Designer's Response

Project	Sefter Farm Engineering Block
Project Number	24125

Comments Received from Adur

Date Comments Received 21 September 2026

DRAWNA Davies	DATEMay 2026	PROJECT NO.24125	
ENGINEERS Magowan	CHECKEDSRM	DWG No.200	REV.-
SCALE1:500 @ A1, 1:1,000 @ A3

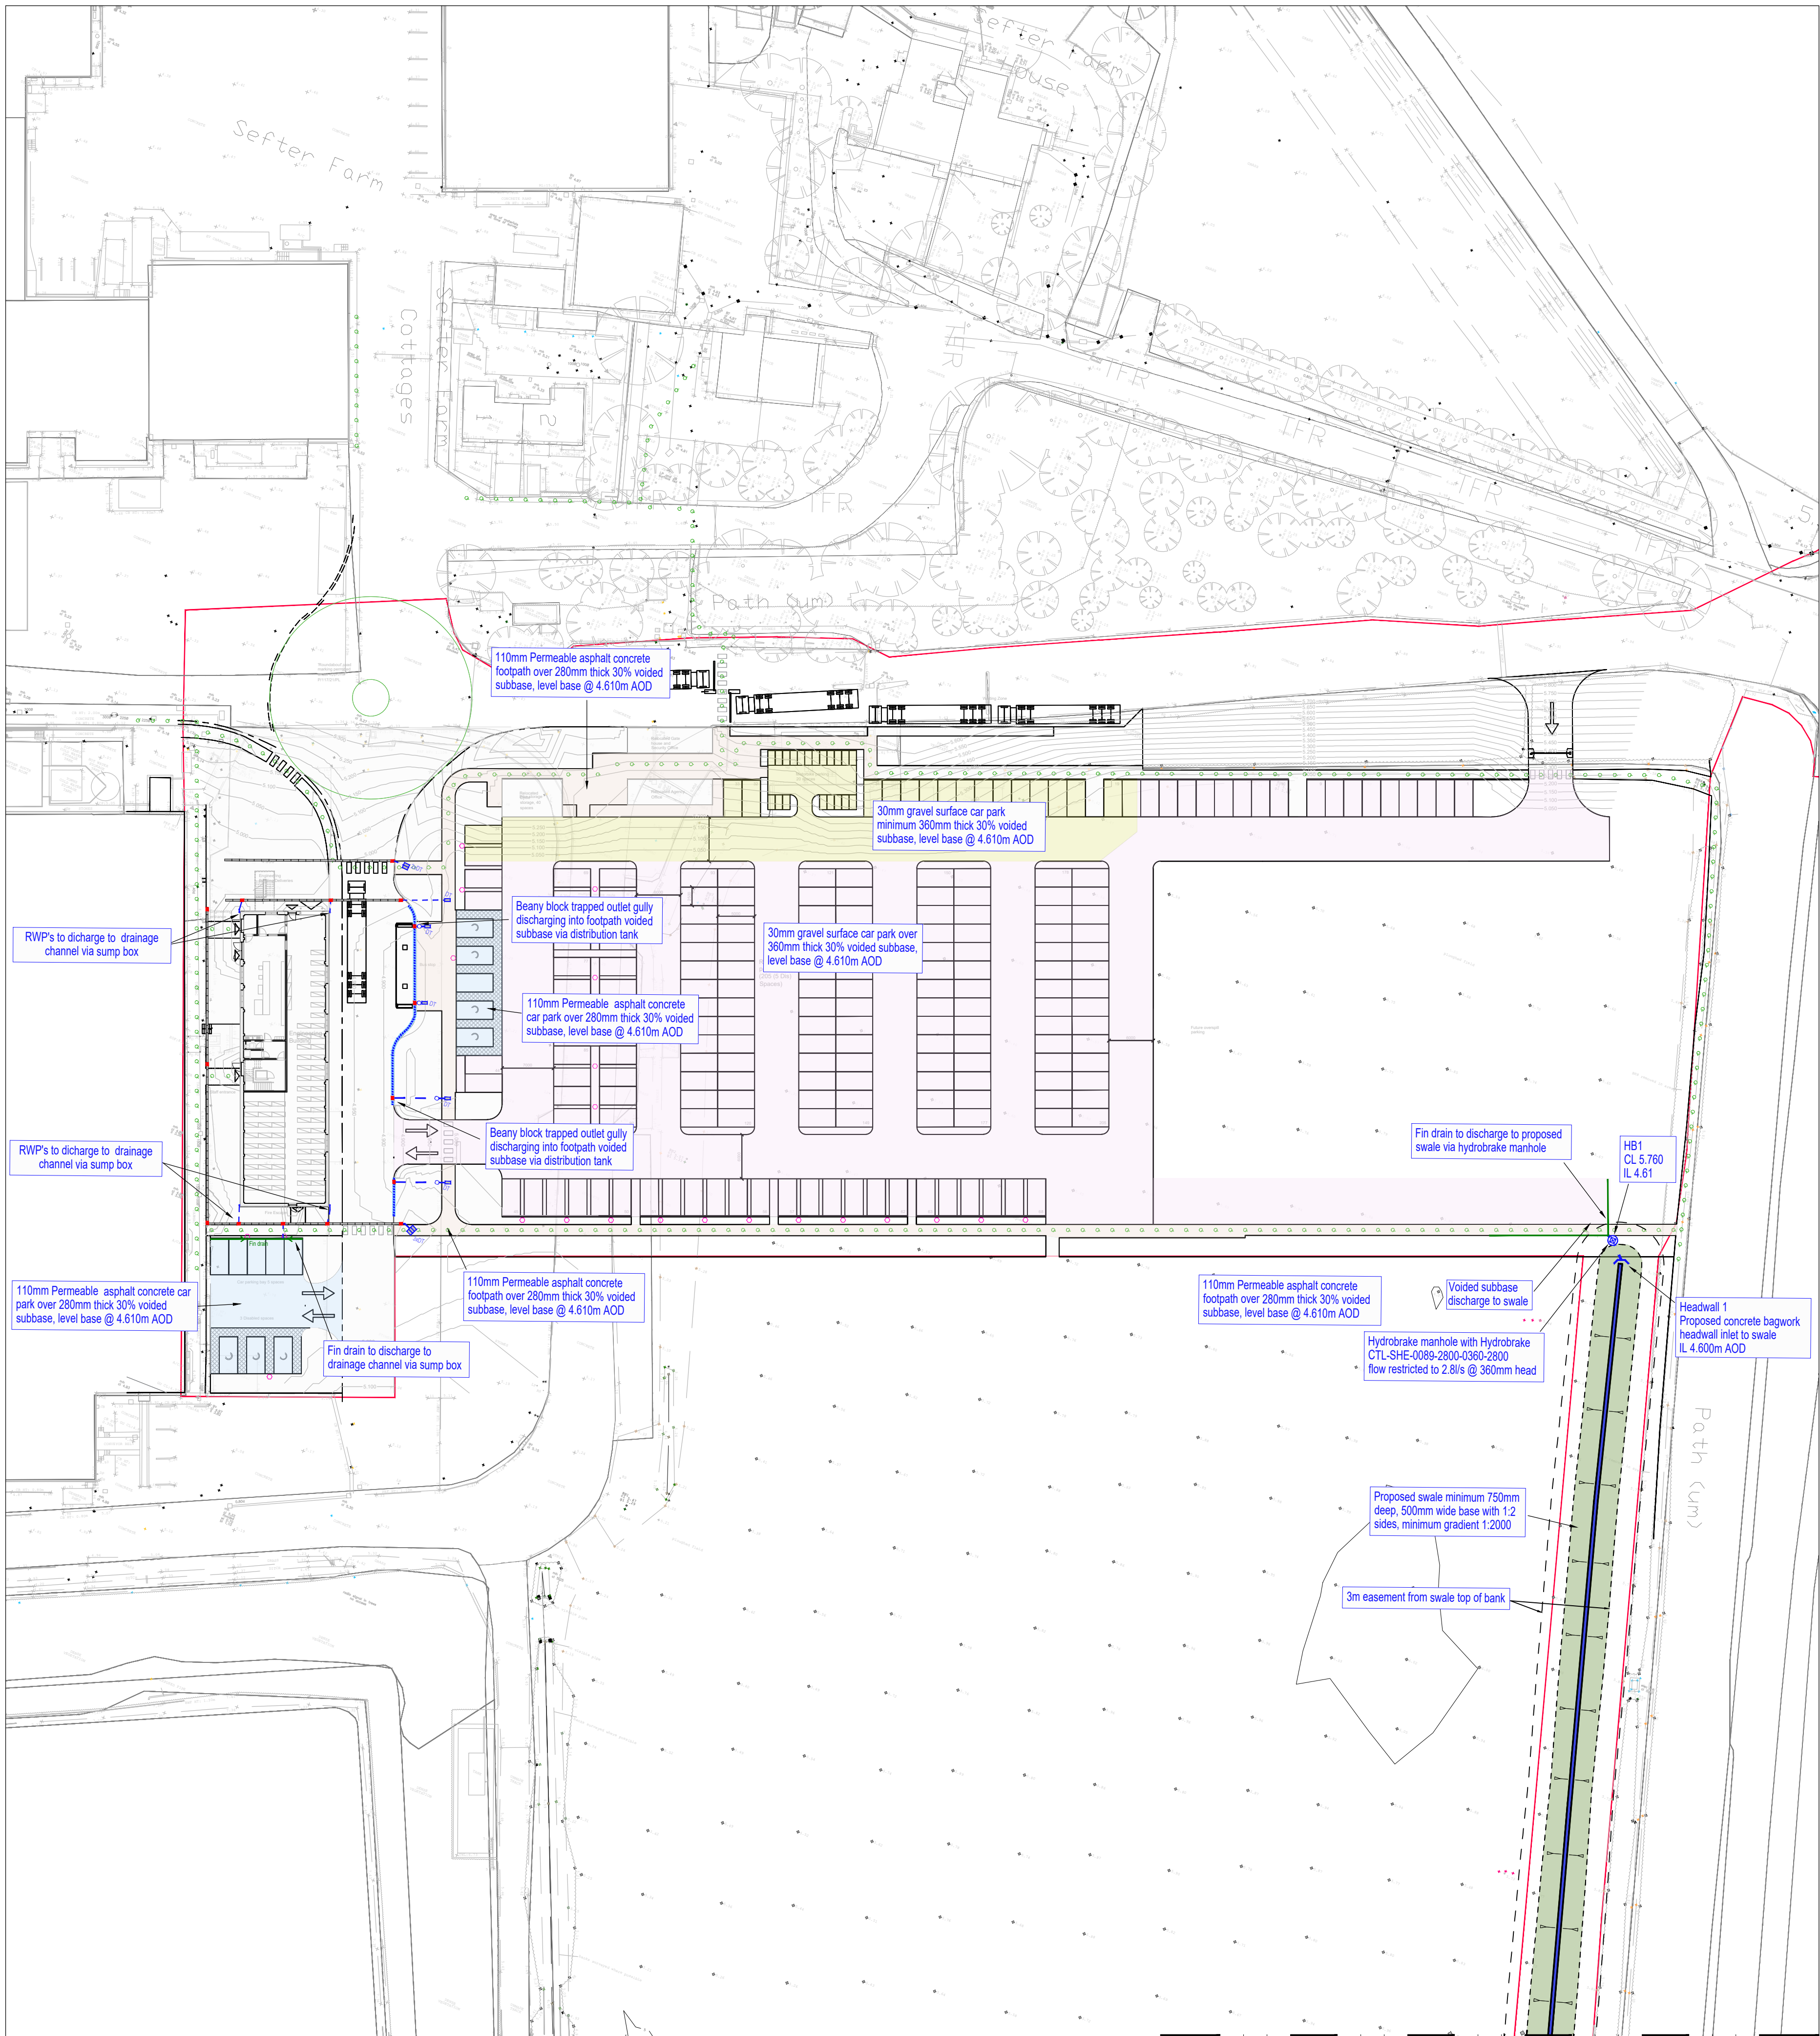
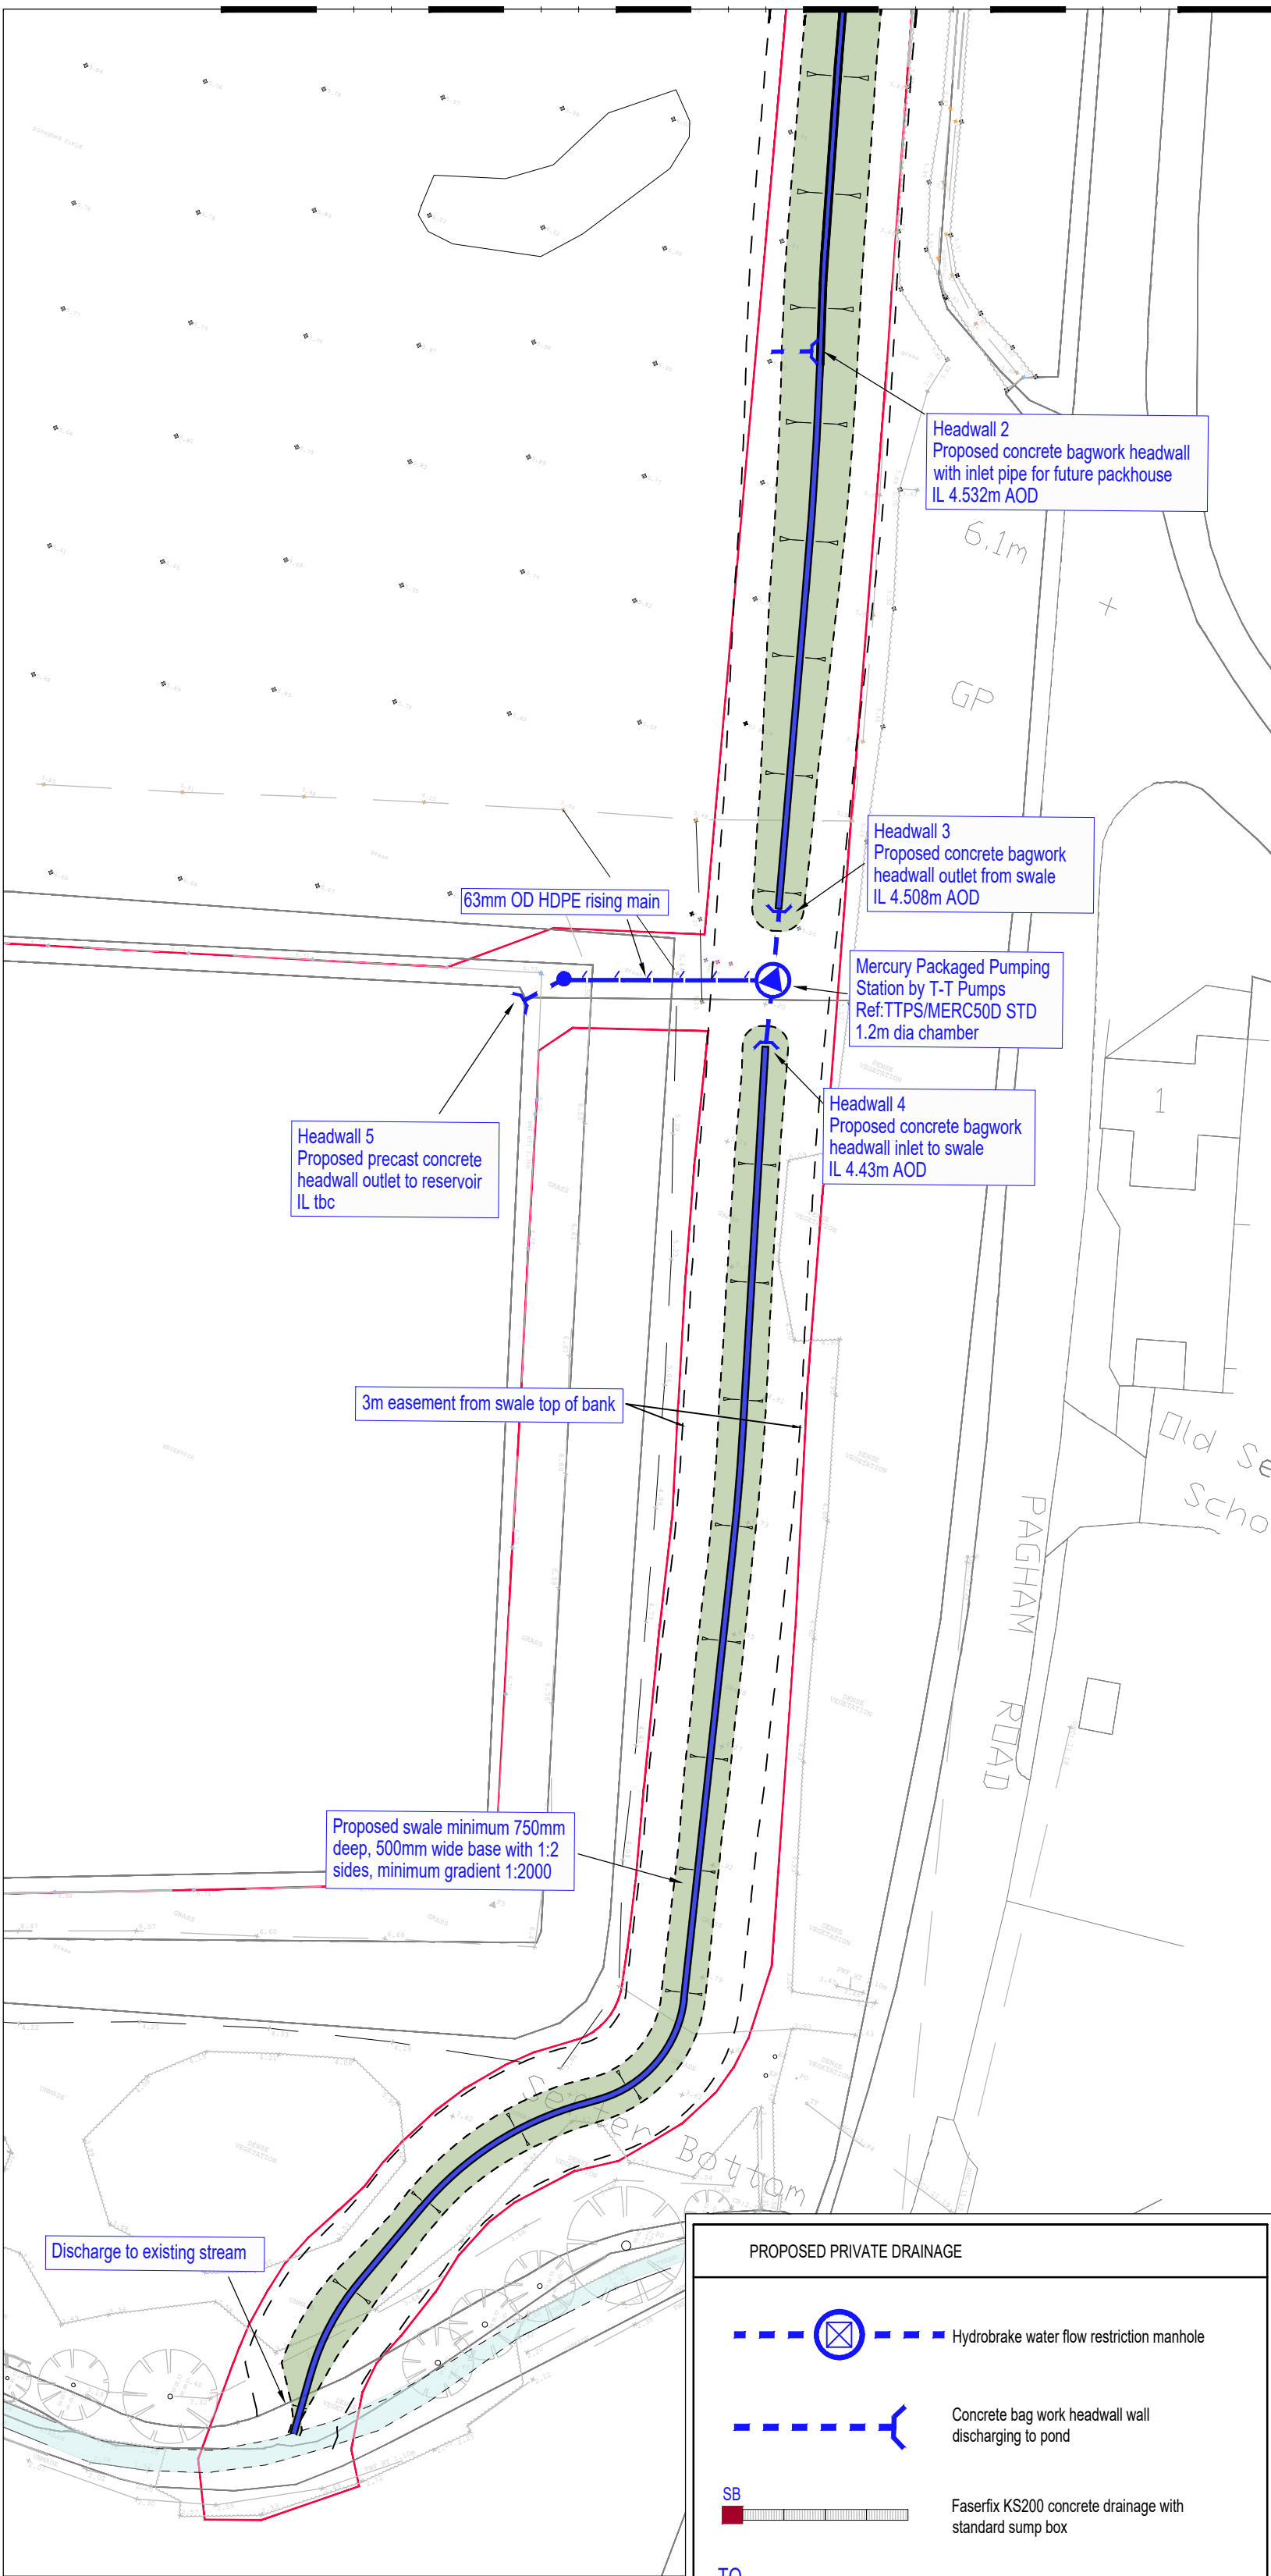
3.2 Calculations are provided which indicate the design storm can be contained within the permeable pavement voided subbase stone layer without flooding. However, the subbase of the footpaths has been calculated with a porosity of 1. This needs to be corrected as the model currently assumes open storage within the subbase of the footpaths, when in fact it is a 30% voided subbase.	This is an error within the footpath calculation which has been corrected to indicate porosity of 0.3. The base of the subbase has been adjusted to 4.545m AOD across the permeable areas and the design drawings have been updated. Please see revised calculations and drawings 200B, 201B, 202A, 501A, 511A and 512A.
